Recommendation Report for Planning Permission for Works or Extension to a Dwelling

REF NO: FP/233/21/HH

LOCATION: 17 Bala Crescent
Felpham
PO22 8LY

PROPOSAL: Single storey rear and side extension, loft conversion and 1 x rear dormer.

DRAWING TITLE
PROPOSED GROUND FLOOR PLAN

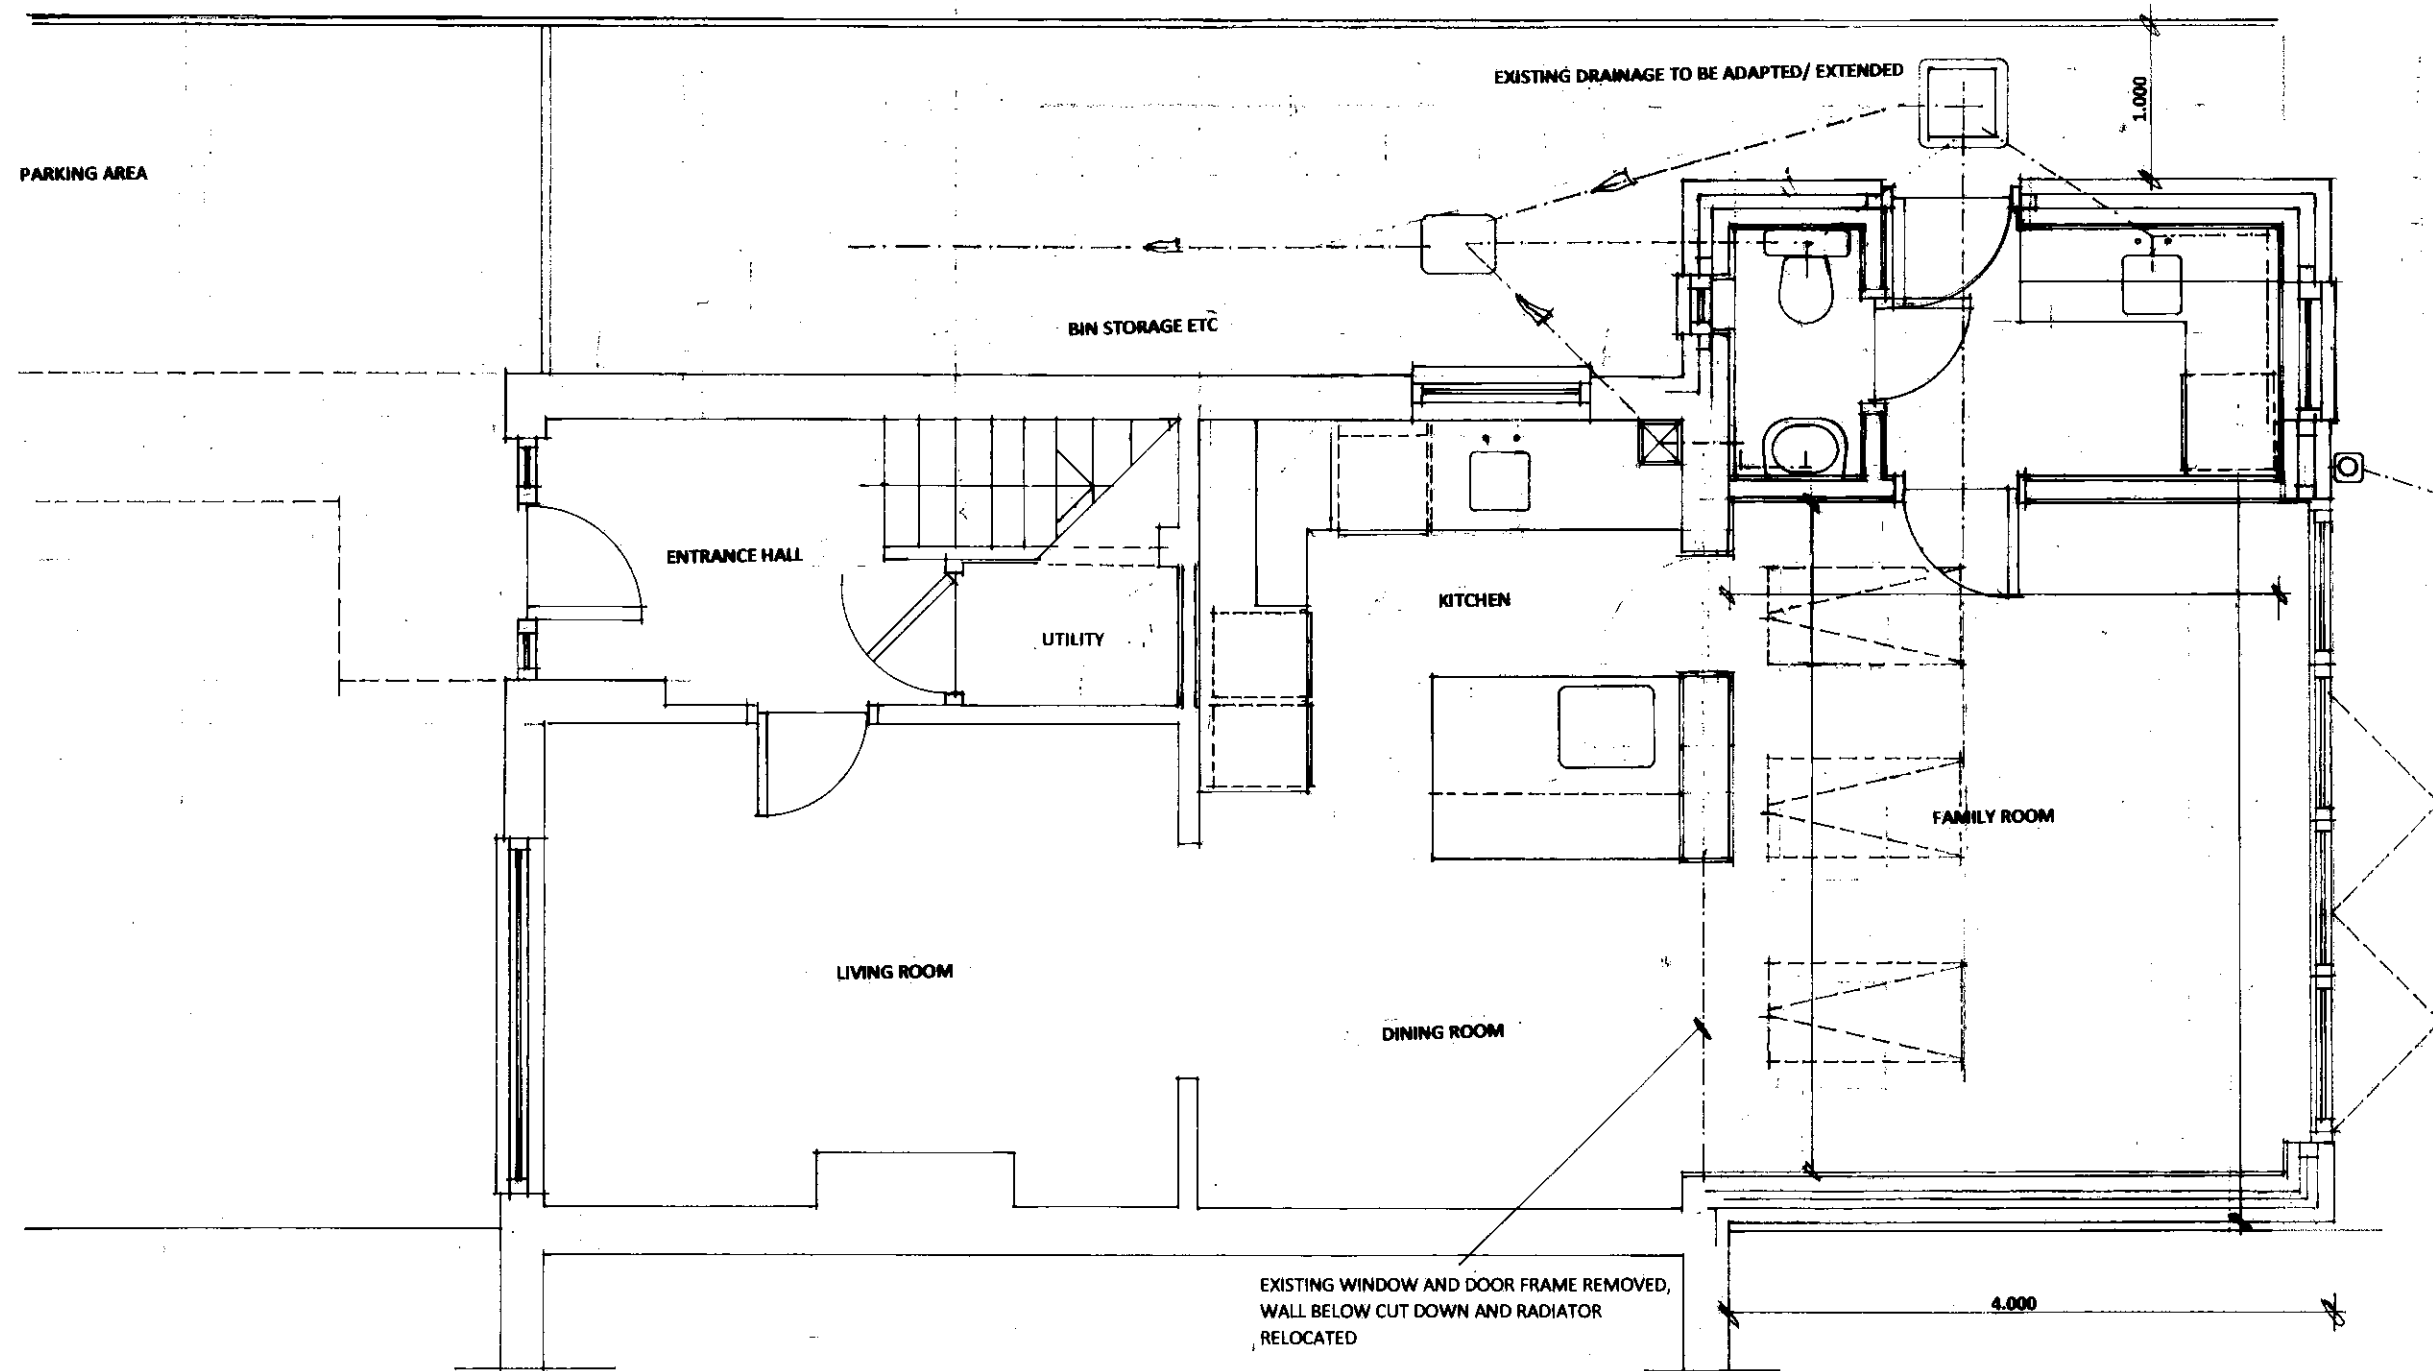
The rear extension will have a depth approximately 4m, running along the full width and extending beyond the western side by 1.3m. It will have a lean to roof with eaves to 2.6m and a maximum height of 3.75m. There is 1m retained to the western boundary of property.

There will be bi fold doors which will provide views over the garden of the host dwelling, similar to existing. There will also be a window to the side addition overlooking the street scene and an access door to the west. This is not considered to provide views which cannot already be achieved from standing in the garden. There is 11m separation to the rear boundary and as such there is no harm upon to neighbours at the rear.

DRAWING TITLE
PROPOSED LOFT CONVERSION

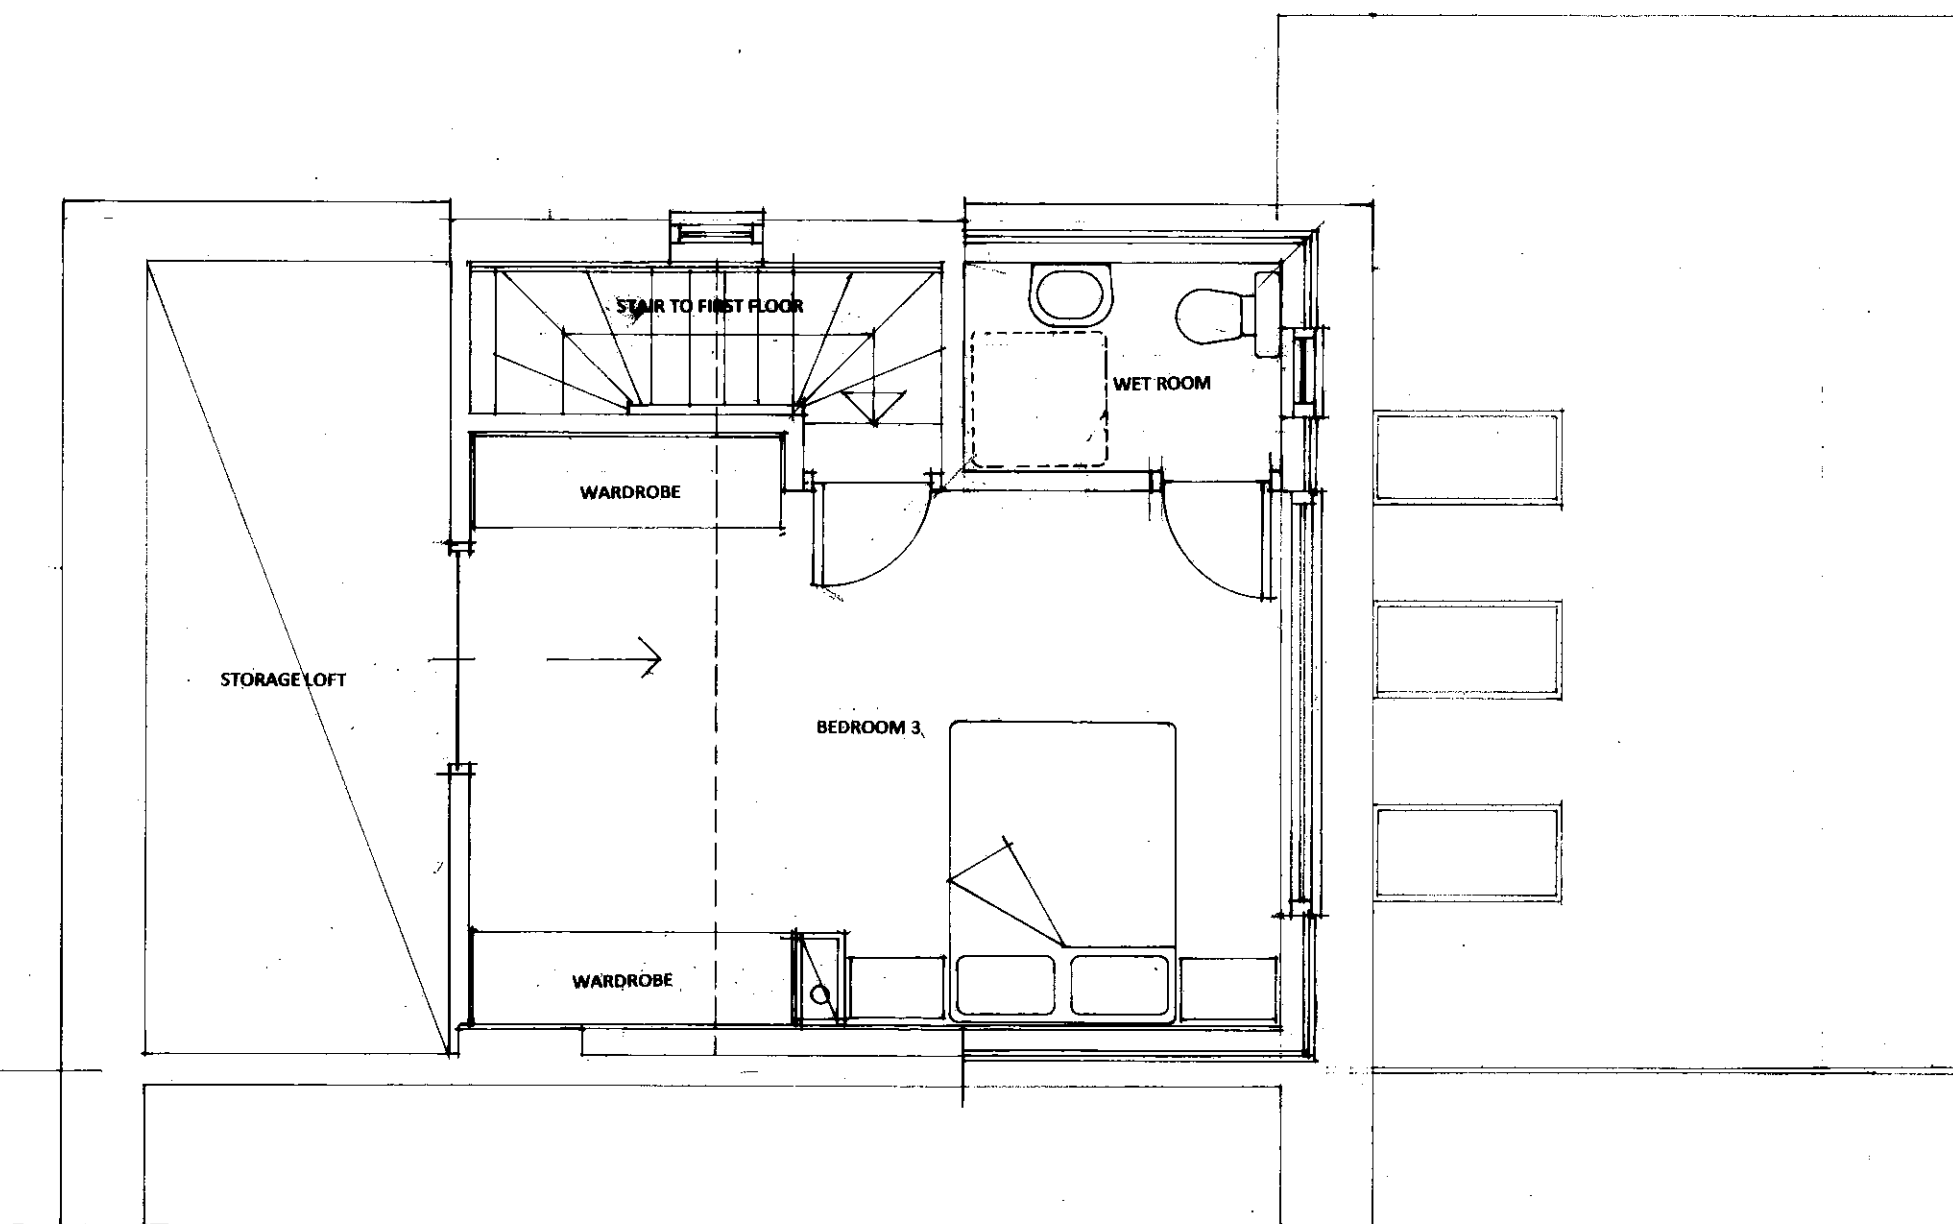
The proposed dormer has a height of 2m, depth of 3.7m and a length of 5.3m. This is not considered to result in adverse overbearing or overshadowing being located in the existing footprint of the roof. There will be 2 windows serving a bathroom and a bedroom. This will provide views over neighbouring gardens which are not currently achievable. However this is not considered significant with no views into direct properties and with similar views achieved under permitted development.

DRAWING TITLE
PROPOSED ELEVATIONS

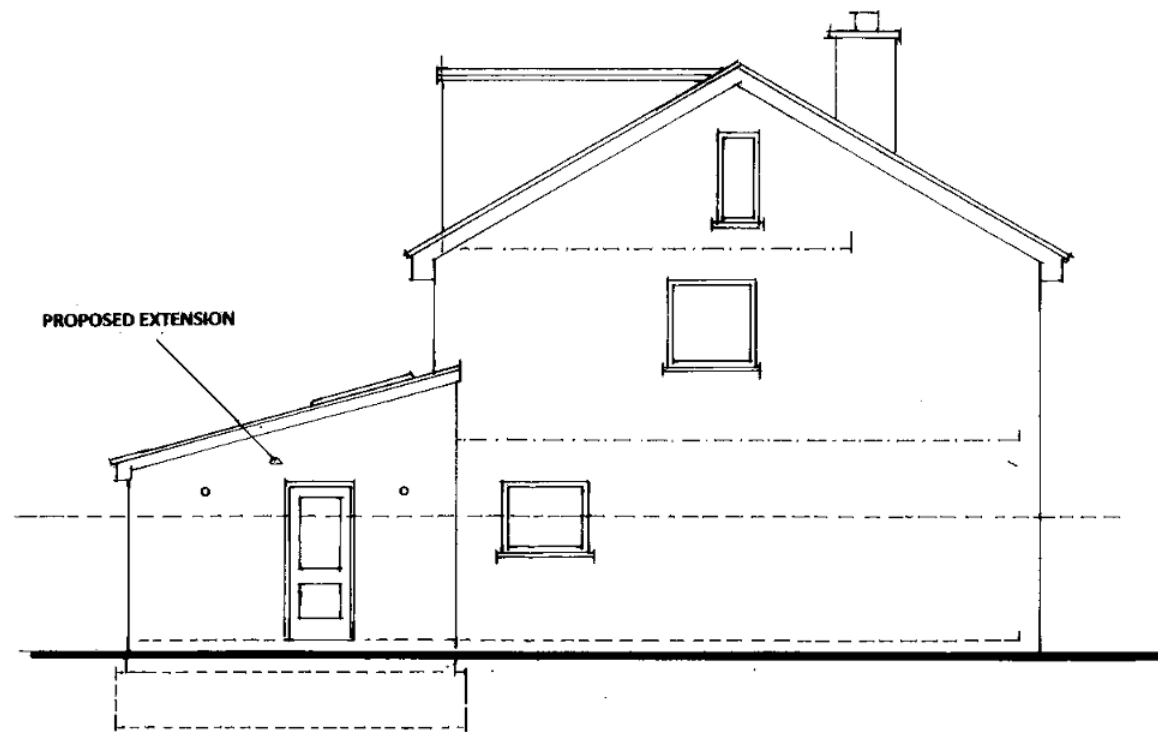
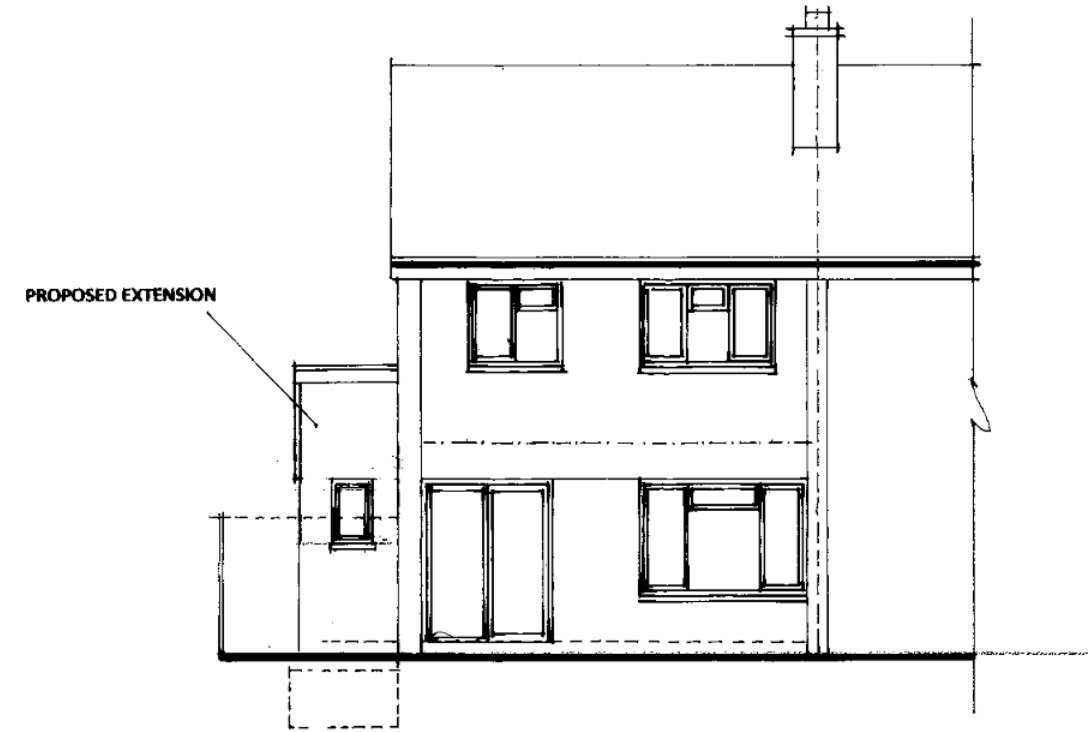
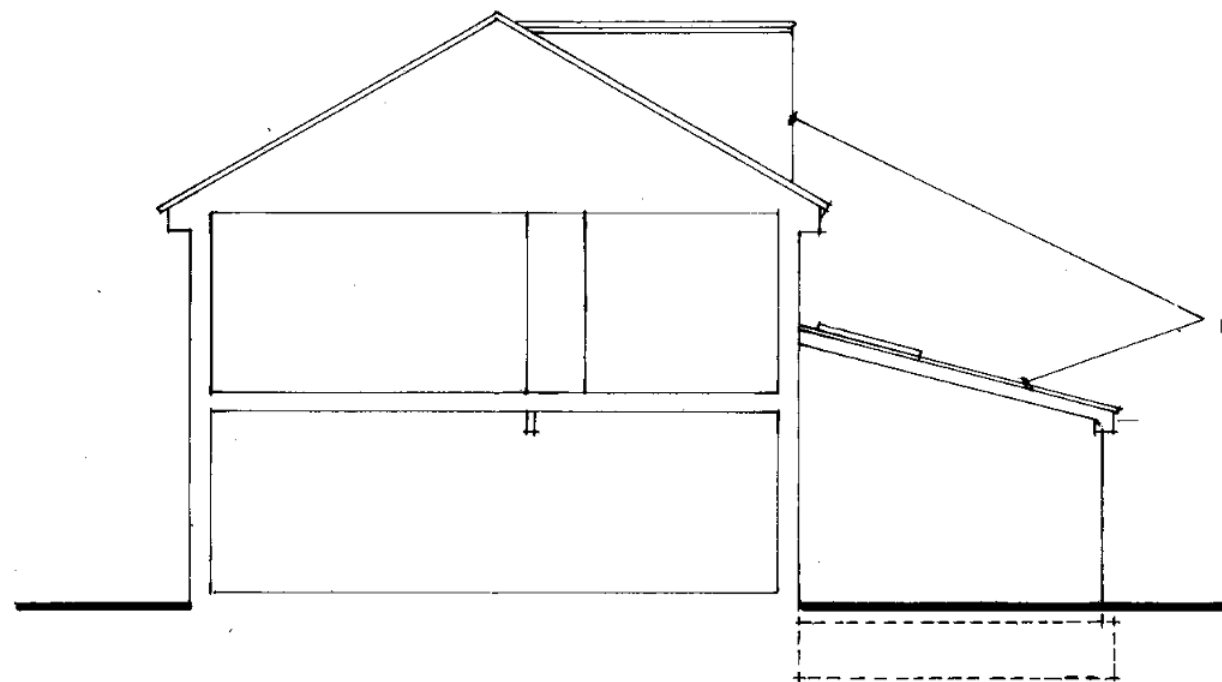
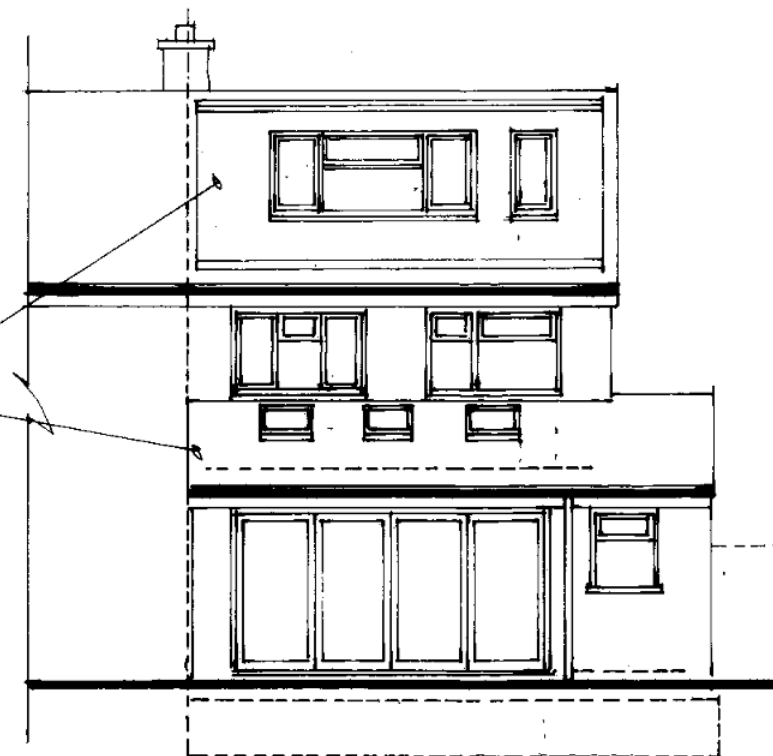
The proposal seeks to construct a single storey side and rear extension and with the property being semi detached, the addition will be visible from the street scene, although views are minimal.

The addition will run along the rear boundary extending beyond the western side by 1.3m forming the side extension. This is located around 7.5m behind the principal elevation and with its width modest in size, it is not considered to appear unduly dominant.

The materials match the existing dwelling and will ensure the proposal appears visually integrated with the host dwelling.
